**Addendum No. 1**

RE: Contract ID C202603

**Wayne County (U-3609A)**

US-13 (Berkeley Blvd.) From Royal Avenue To South Drive In Goldsboro

Terminal Compartment Detail

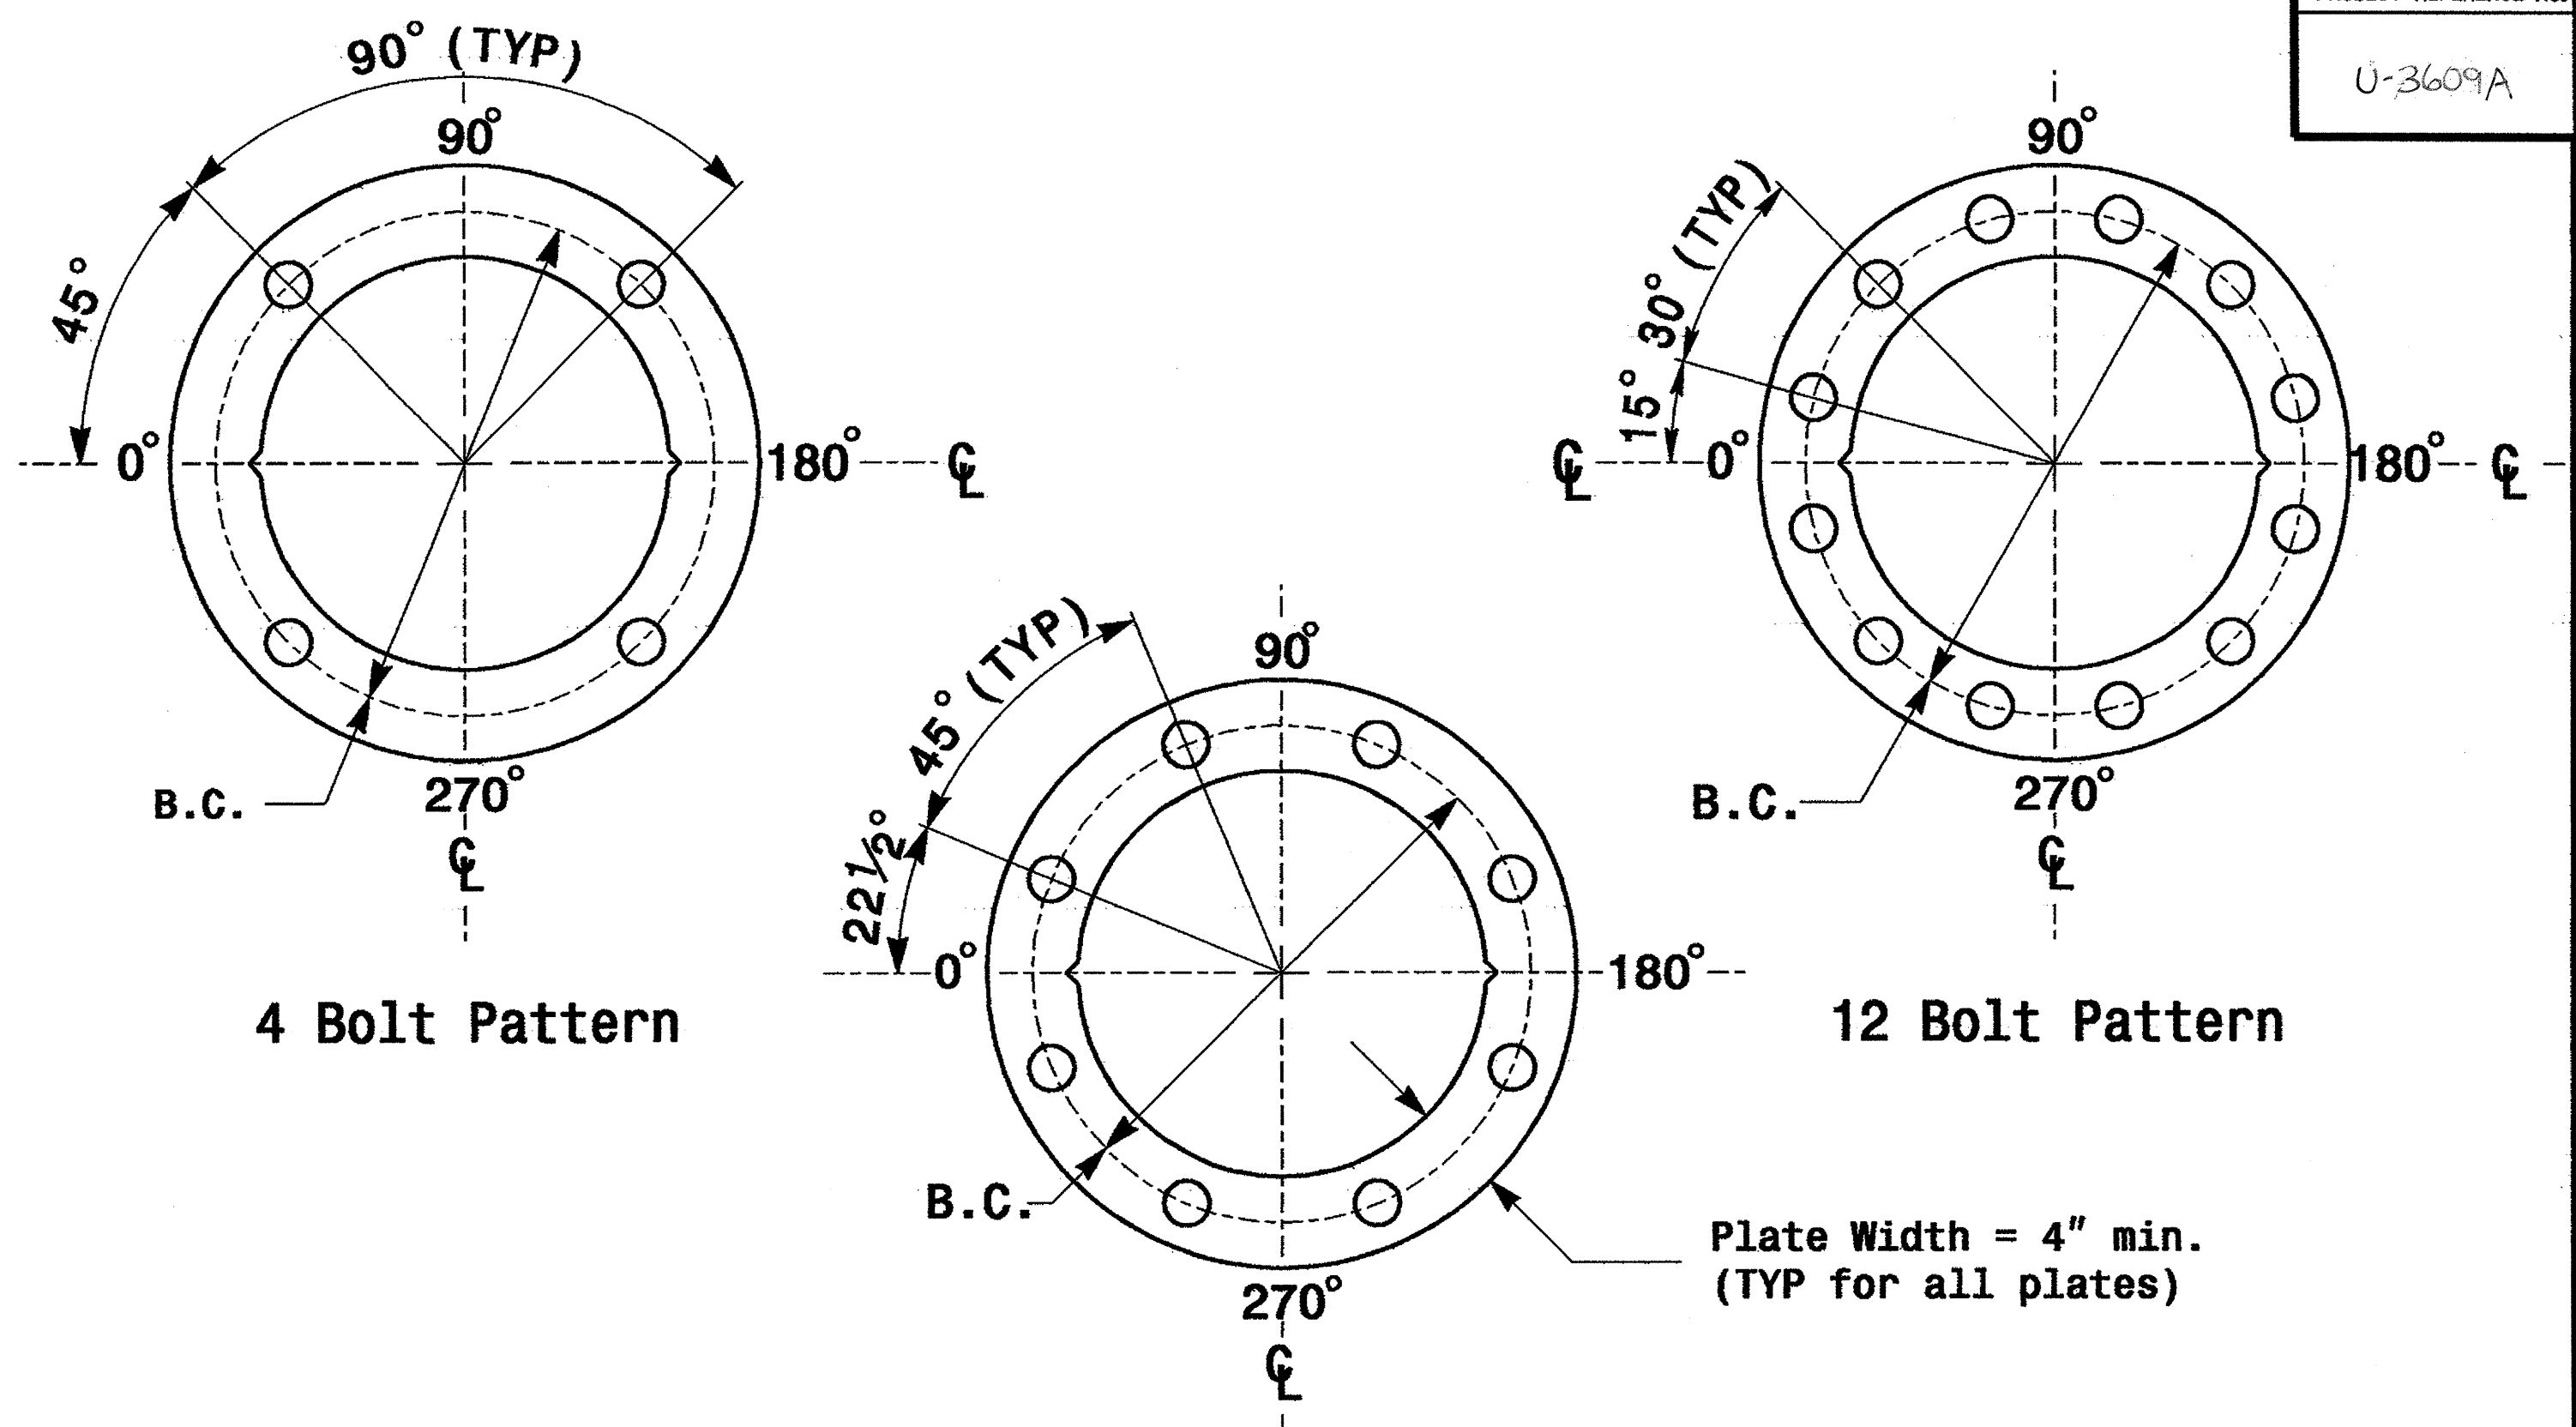
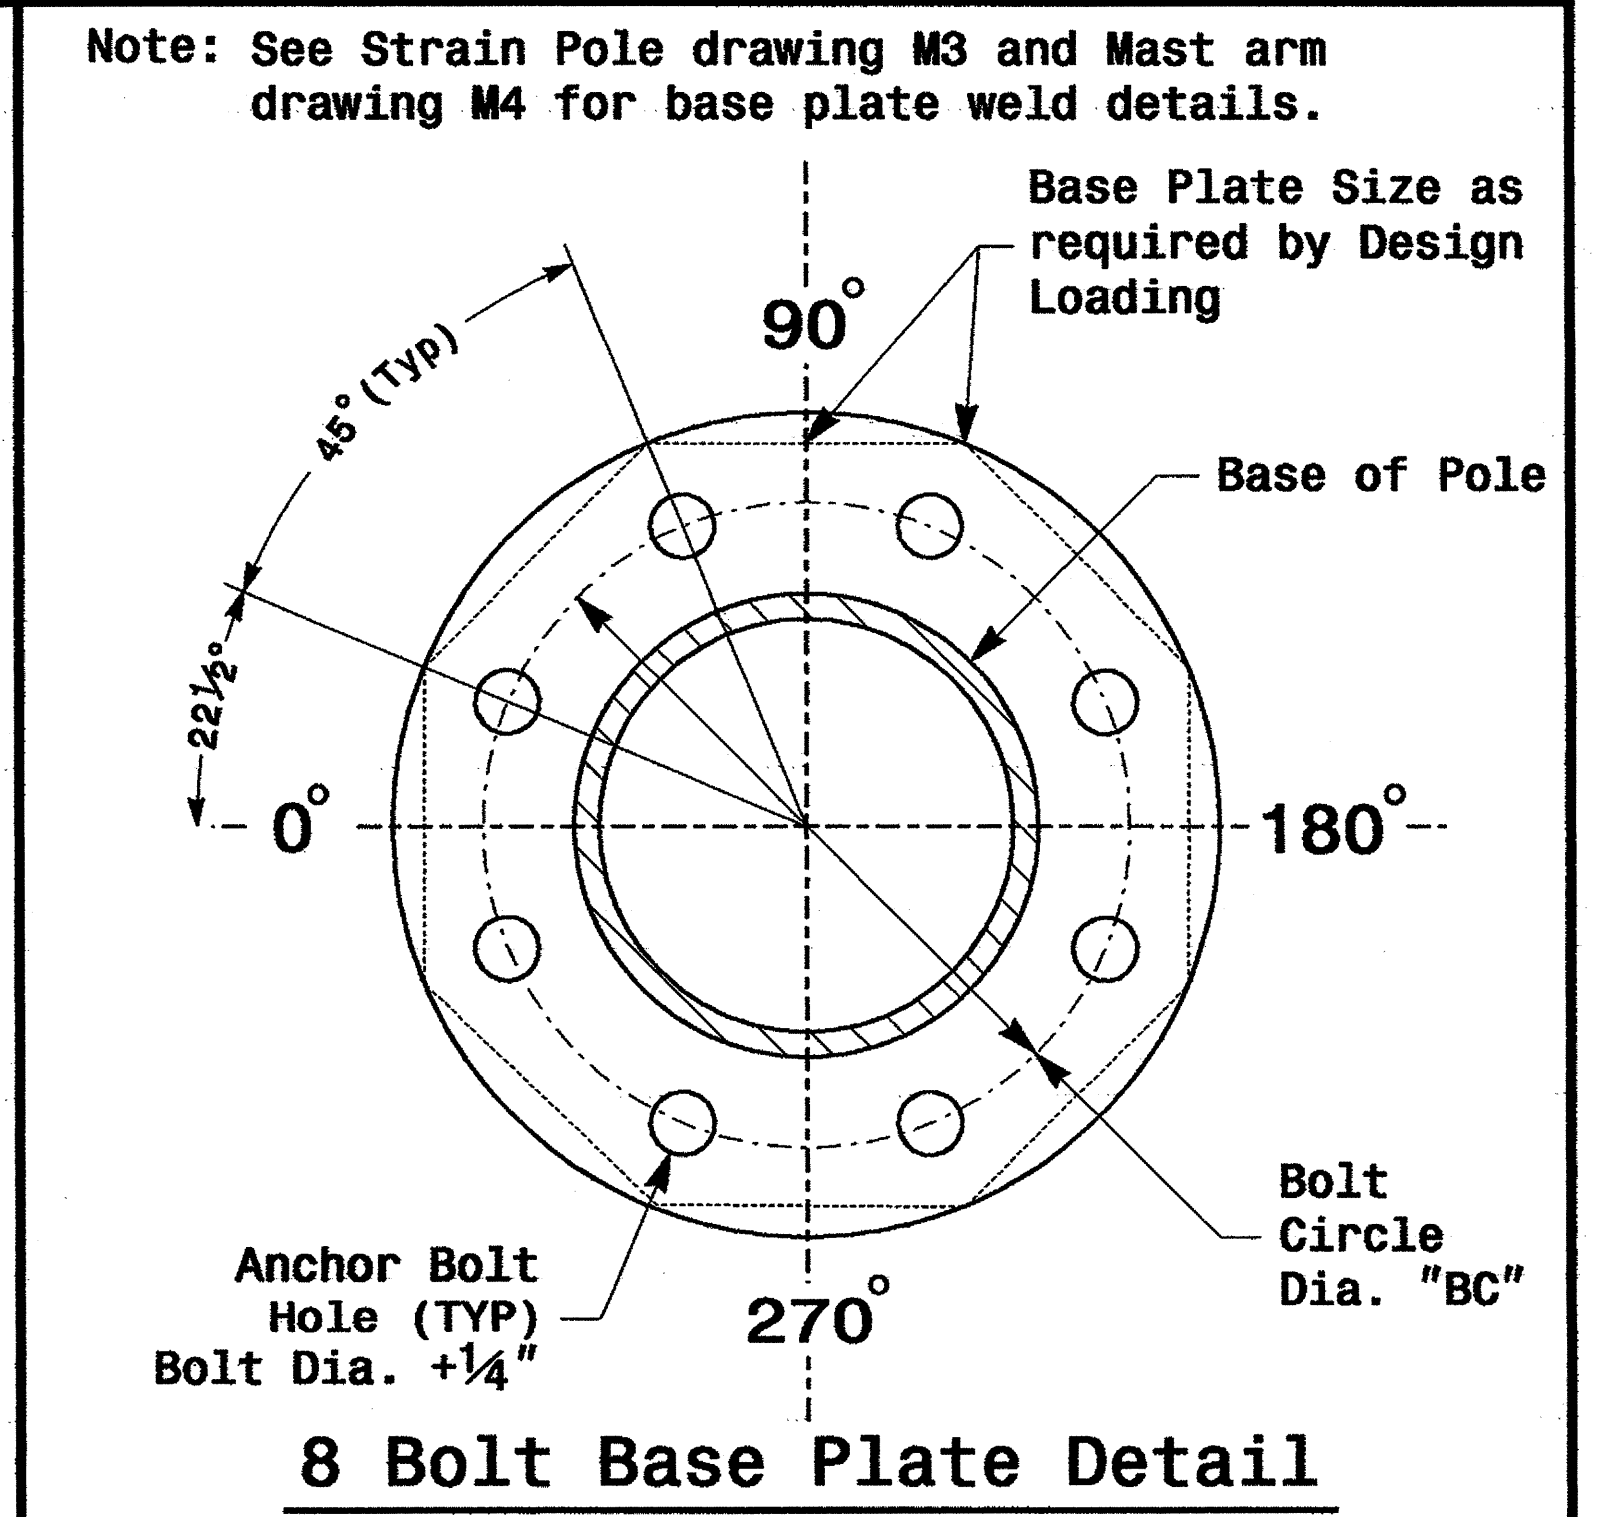
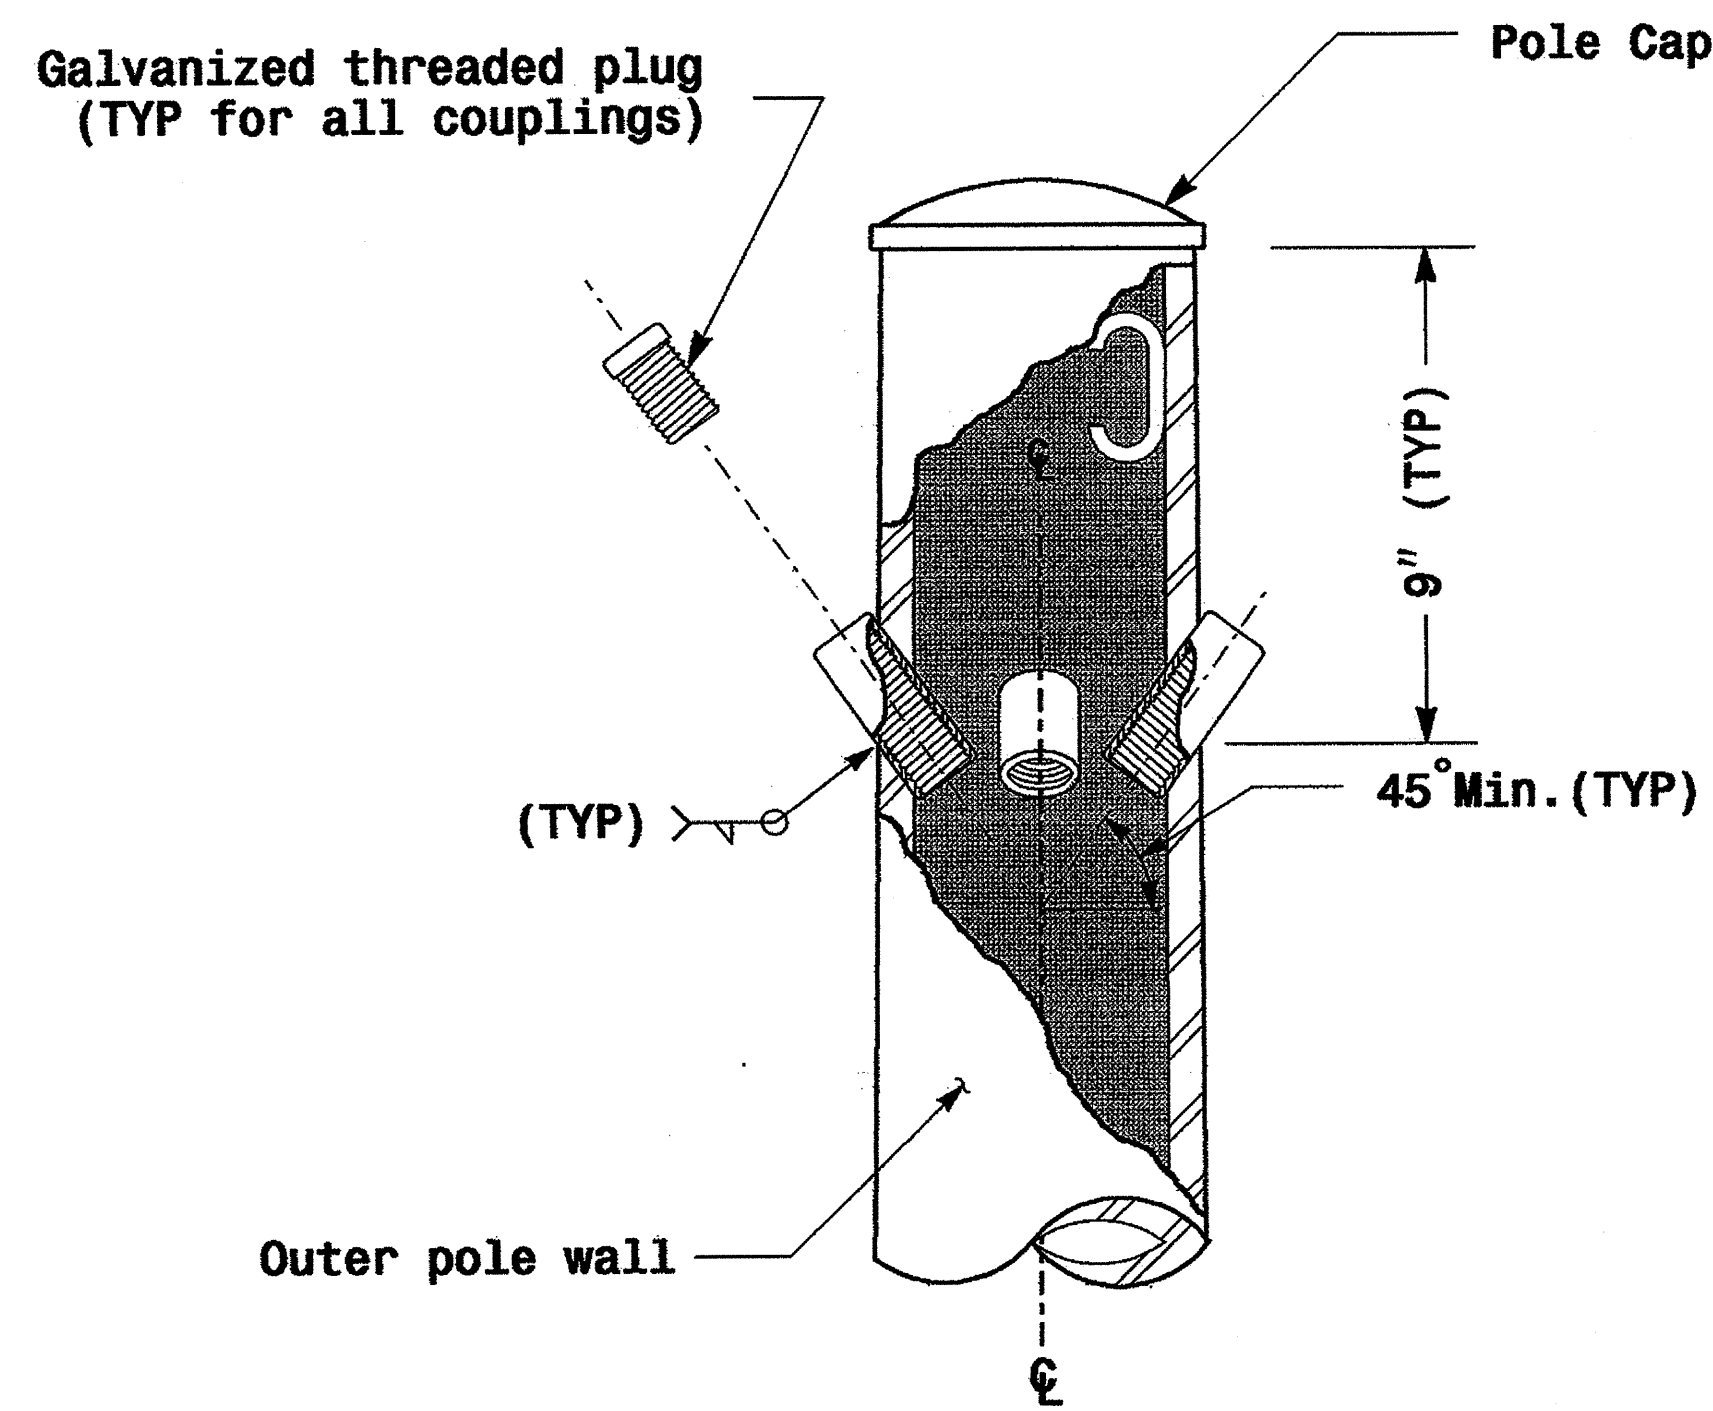
Sheet No. SIG-10 has been revised to show the case number for the metal poles. Please void Sheet No. SIG-10 in your plans and staple the revised Sheet No. SIG-10 thereto.
